CITY OF ALBUQUERQUE

May 8, 2020

RE: **Catalonia Subdivision**
Tr 1 & 2, The Trails Unit 3A
Revised Drainage Report Stamp Date: 3/25/20
Revised Grading Plan Stamp Date: 2/13/20
Hydrology File: C09D013

IN2-IN3

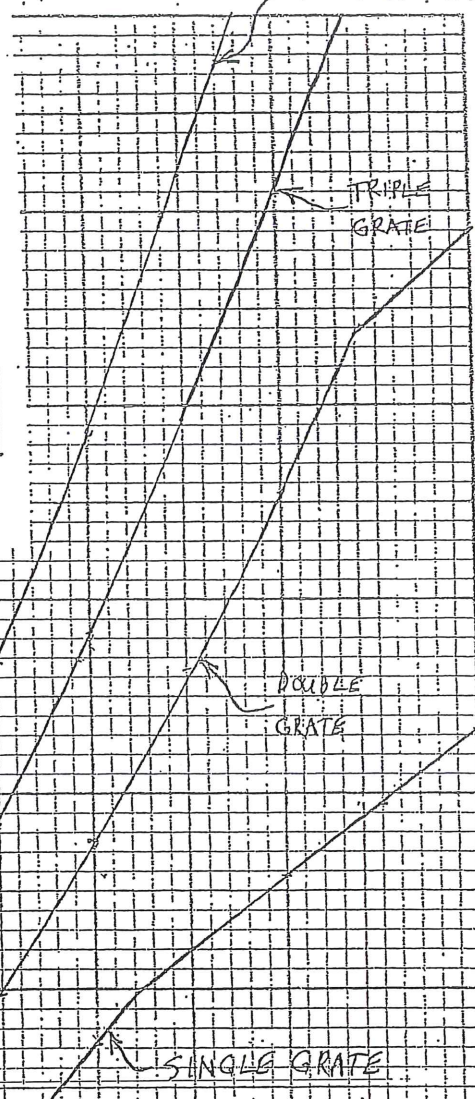
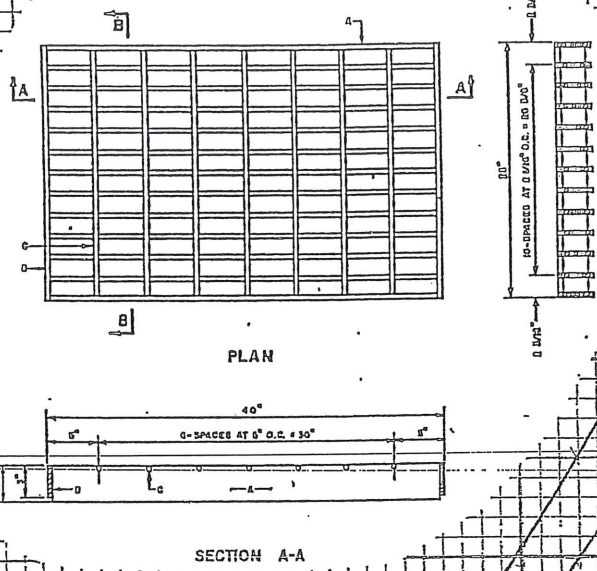
1. The 24 x 36 Storm Drain exhibit needs to be consistent with the Appendices analysis. For instance, IN2&3 are called as Type-C, but are Type-A per the analysis and the storm pipe sizes and flows do not match.

3. IN2 needs to be a double inlet to accommodate the 42" inlet and outlet pipes; otherwise use a manhole and lateral for this junction.

Response: Inlets have been updated to reflect the correct type and the flowrates have been updated accordingly.

Response: Inlet 2 has been updated accordingly

Profile Report
Engineering Profile - Profile - 1 (20190248.stsw)

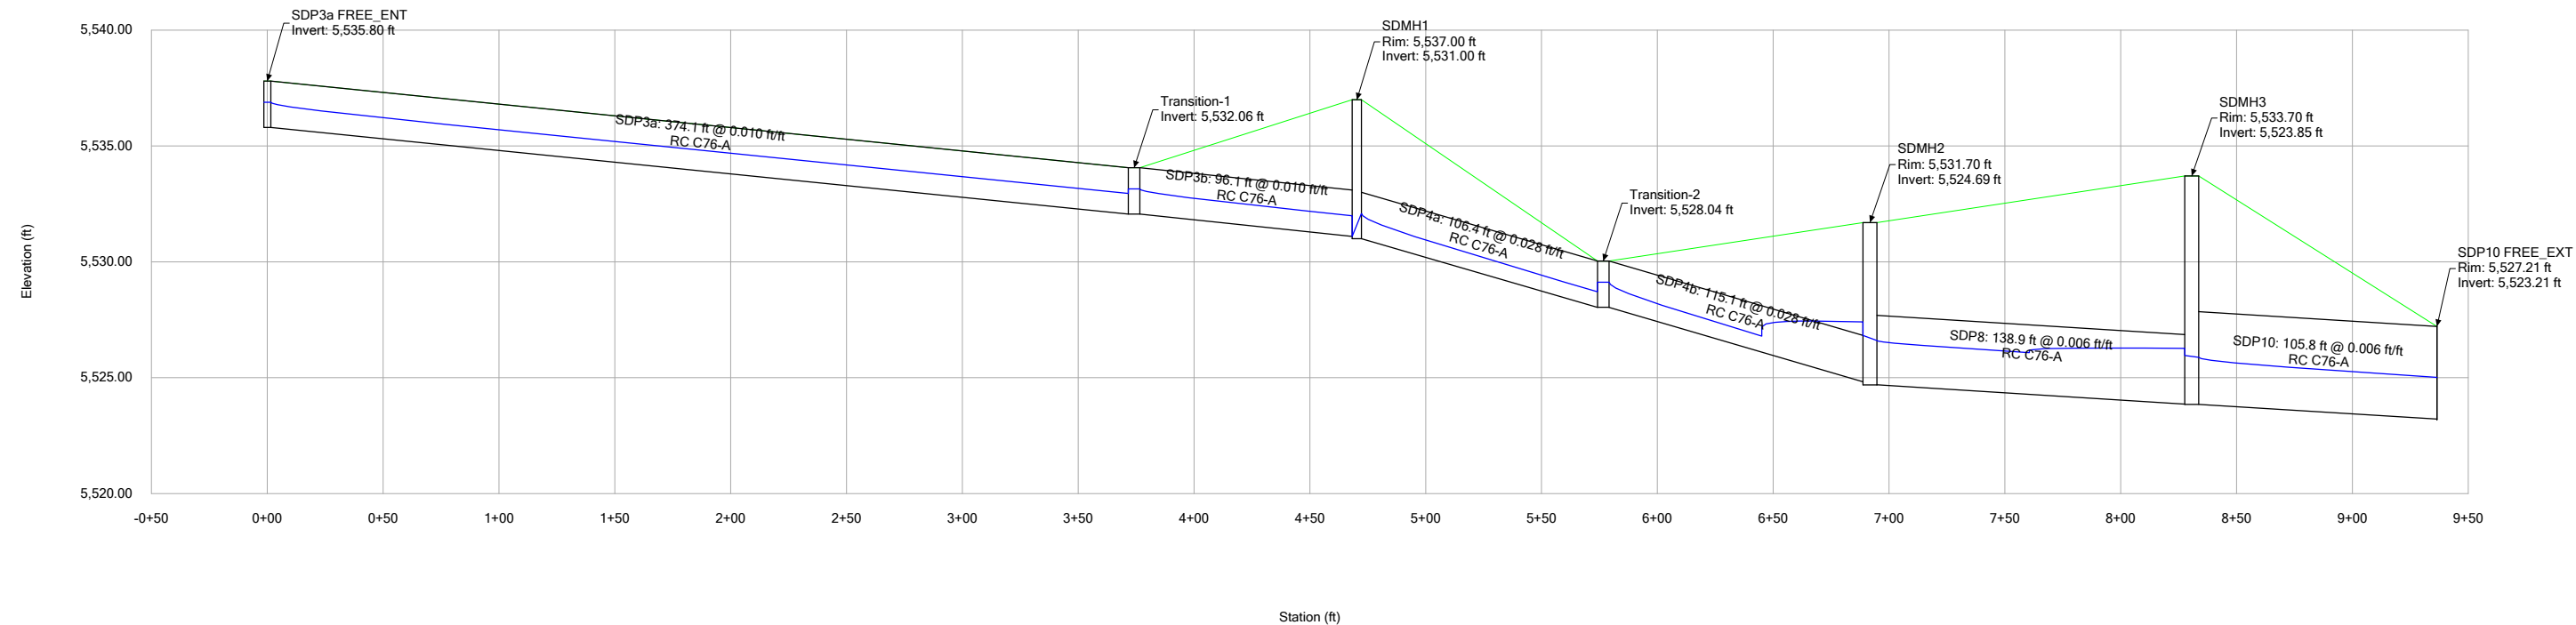
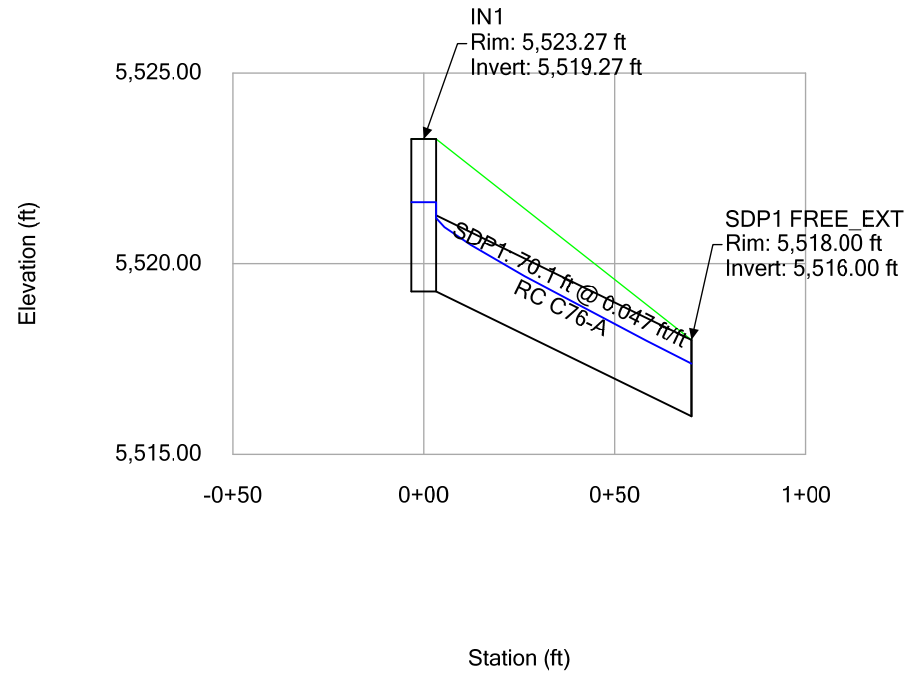
2. Provide the Stormwater Studio files for the storm drain; applied bend losses at SDMH9 seem especially suspect.

Response: Stormwater Studio file is attached.

CATALONIA
OVERALL GRADING PLAN

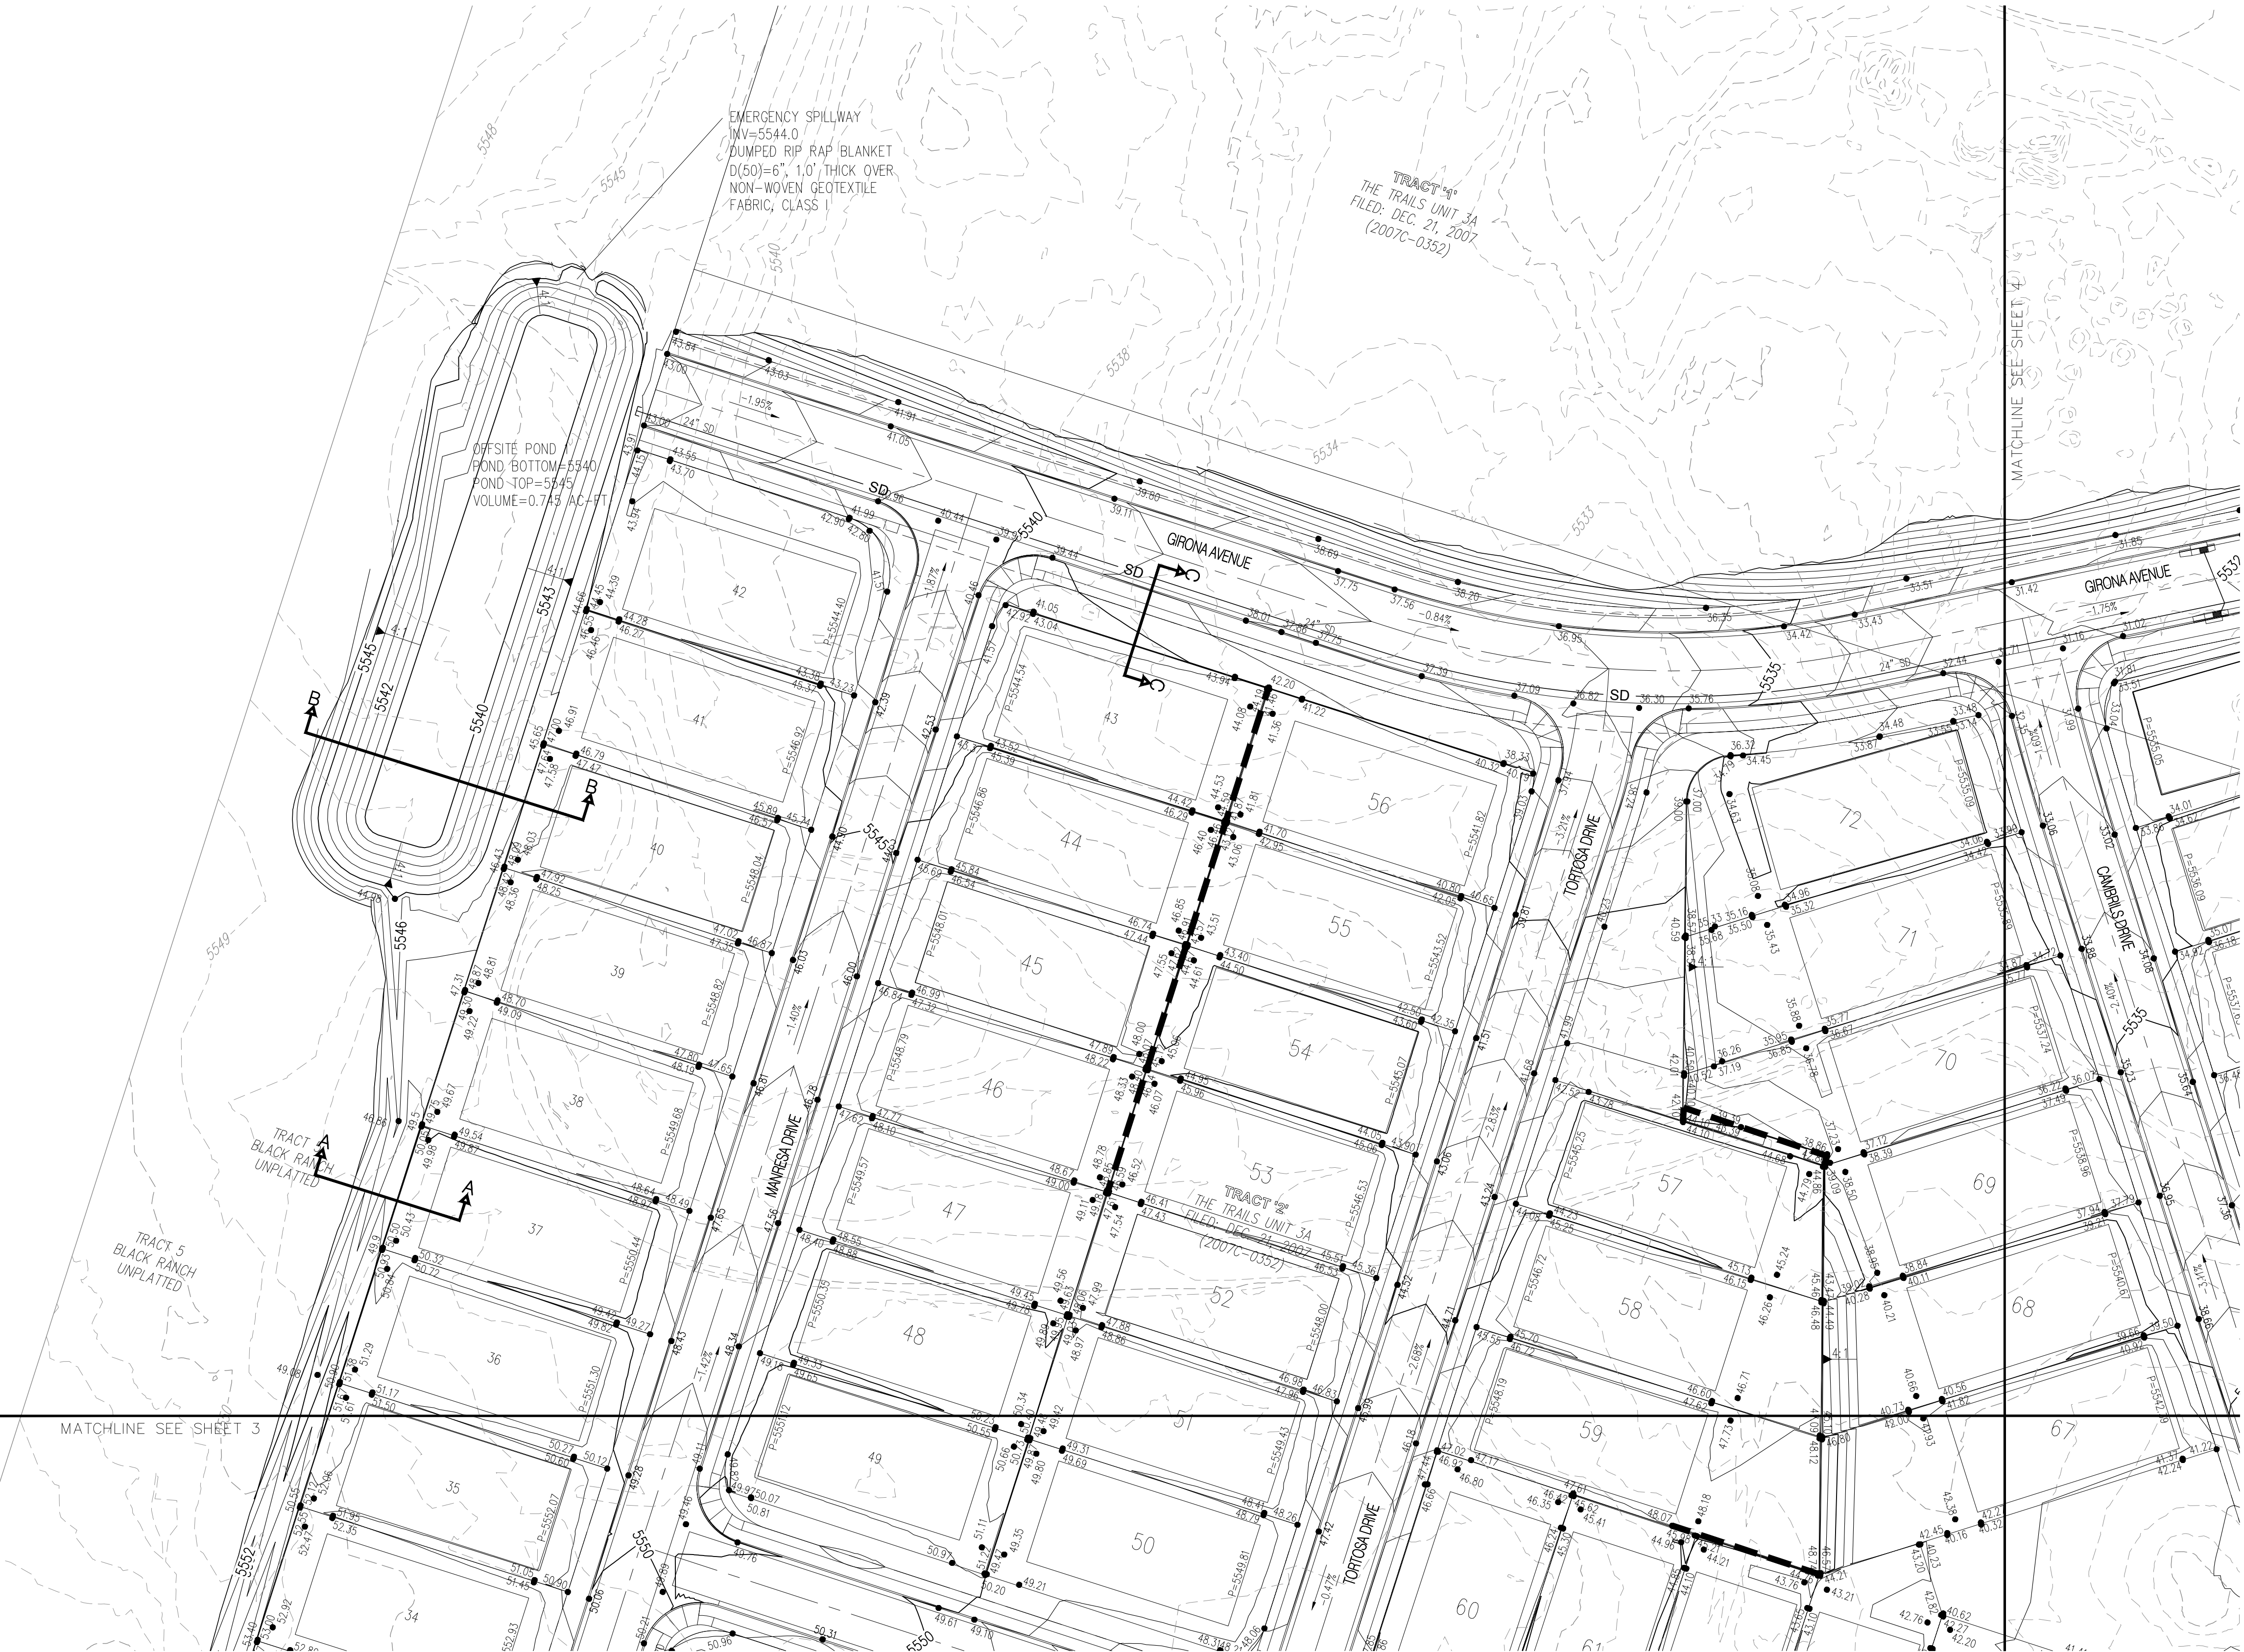
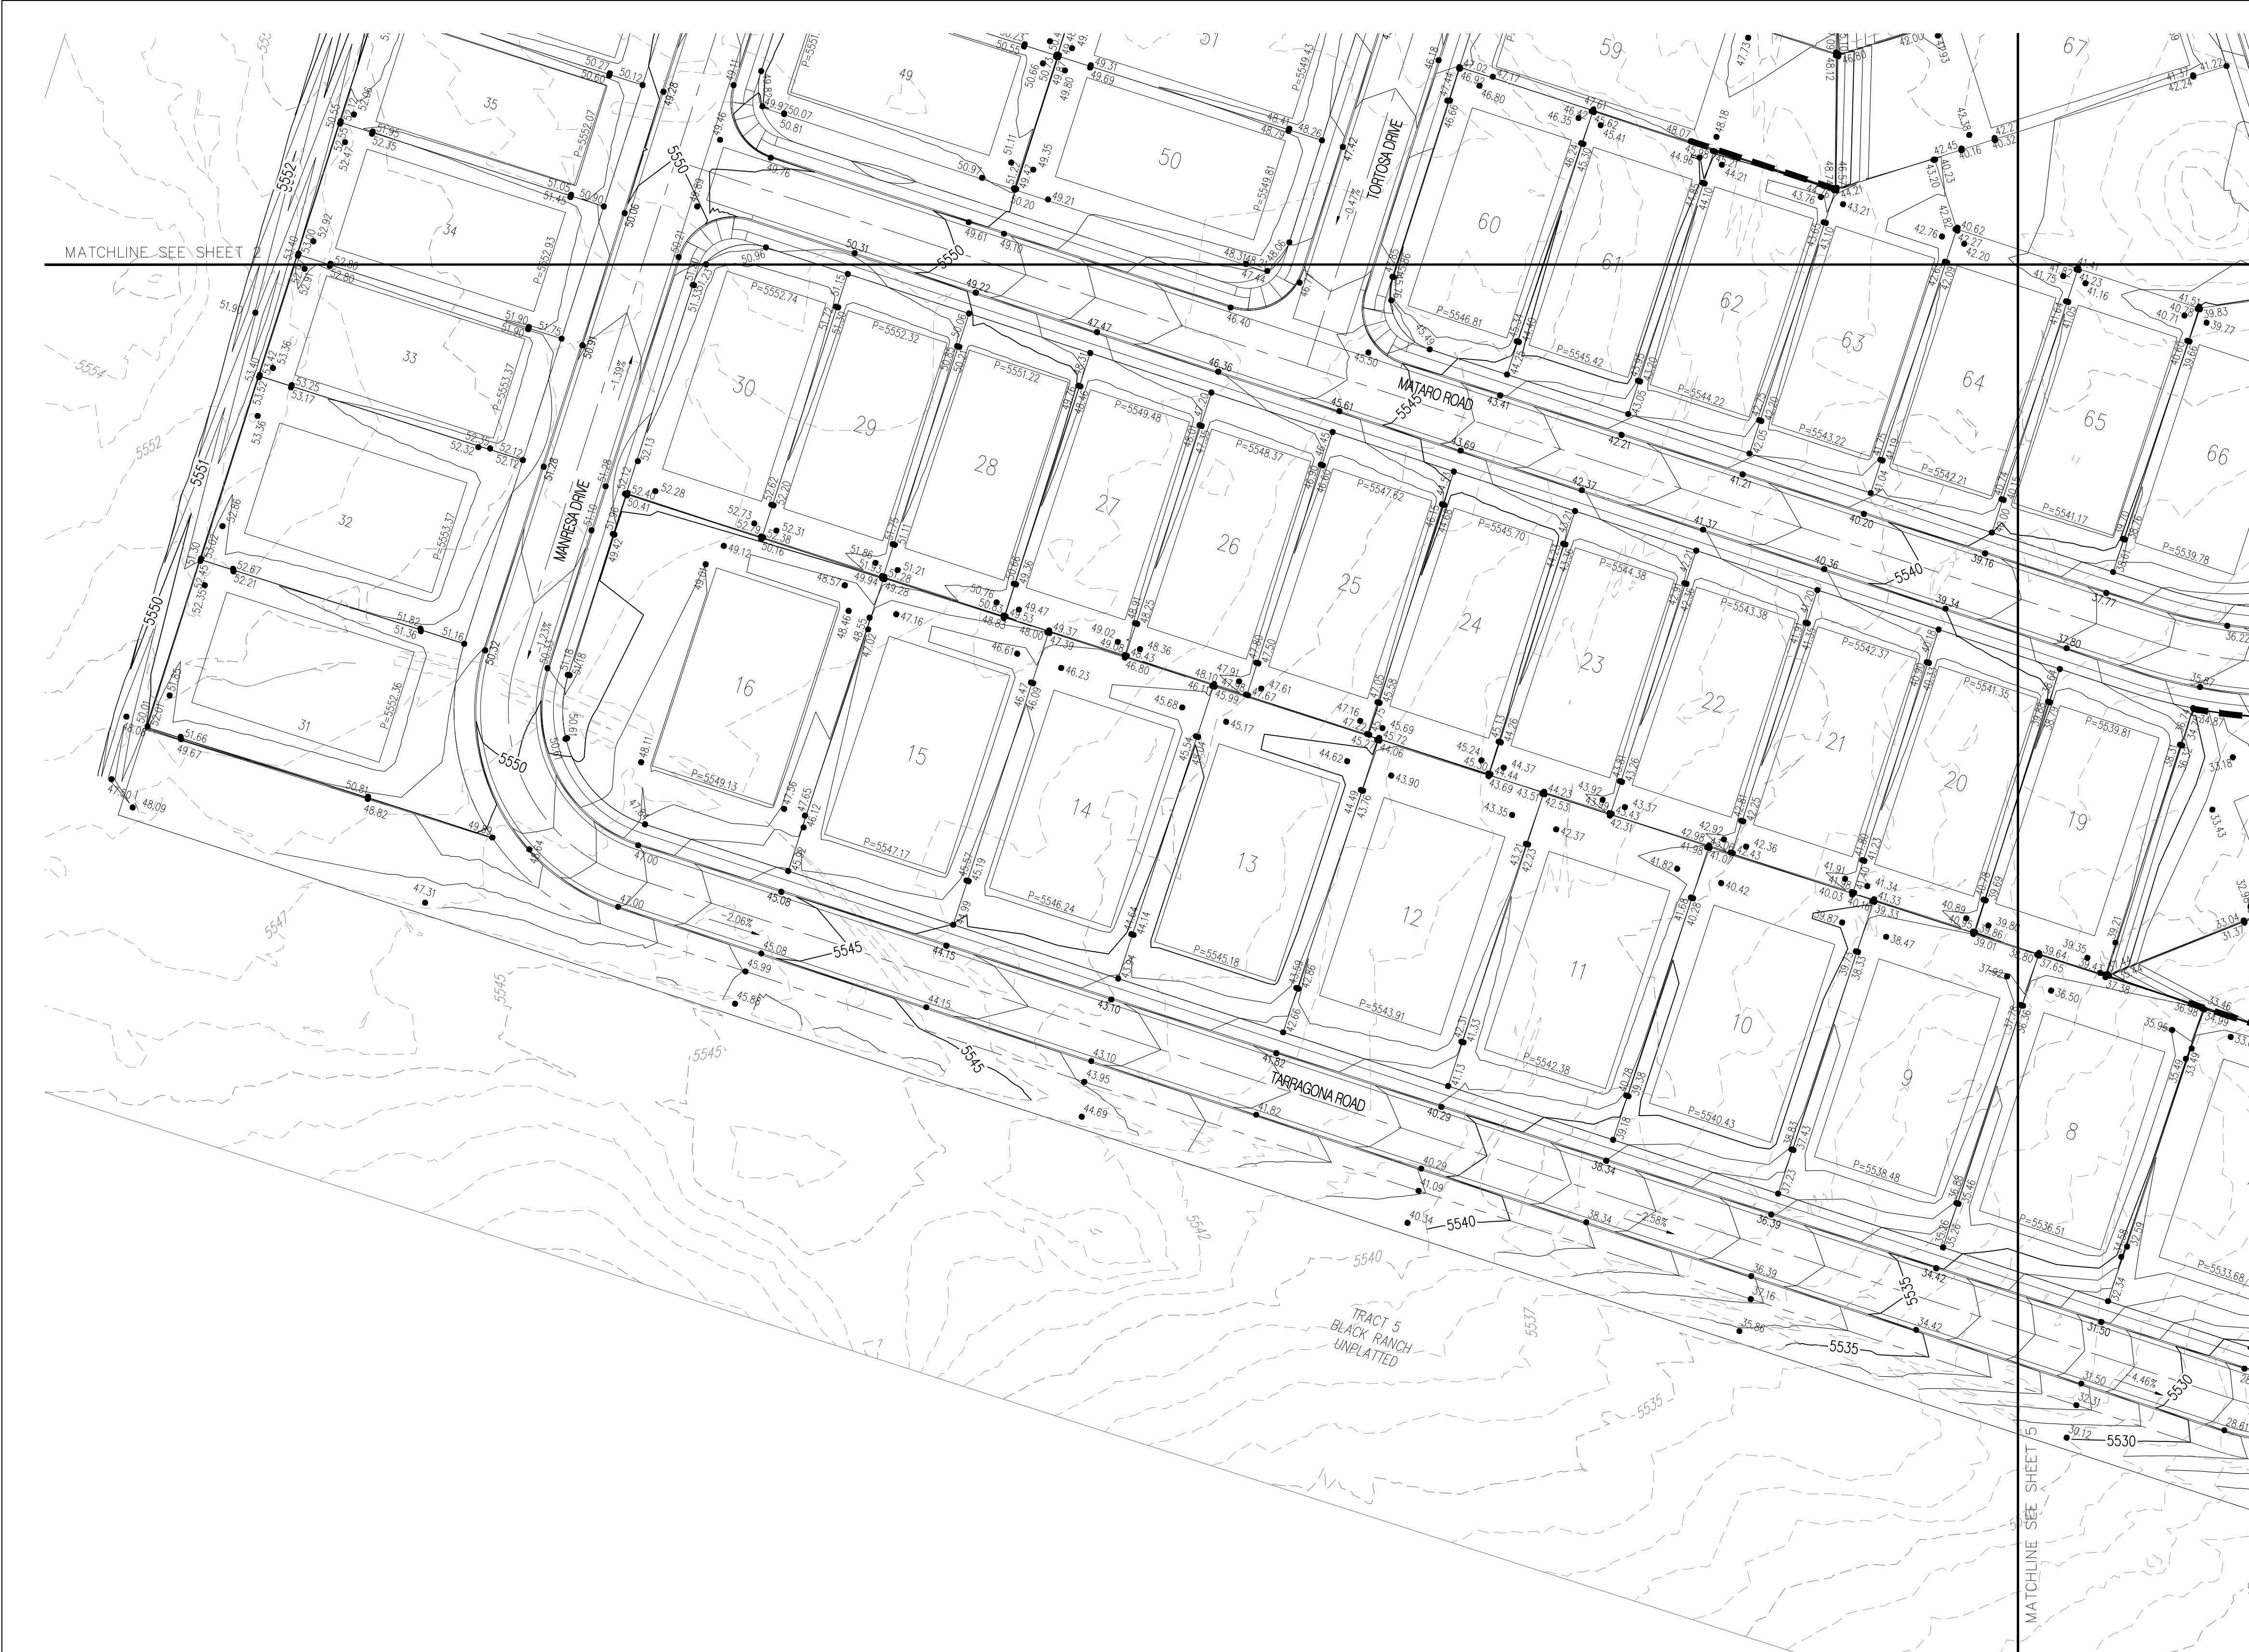
1. Provide an easement and drainage covenant for Pond A. The easement must be recorded prior to approving the Work Order.

4. Provide an easement and drainage covenant for Pond A. The easement must be recorded prior to approving the Work Order.

Response: The final plat will be updated to reflect a drainage easement where Pond A will be going within Tract 10.
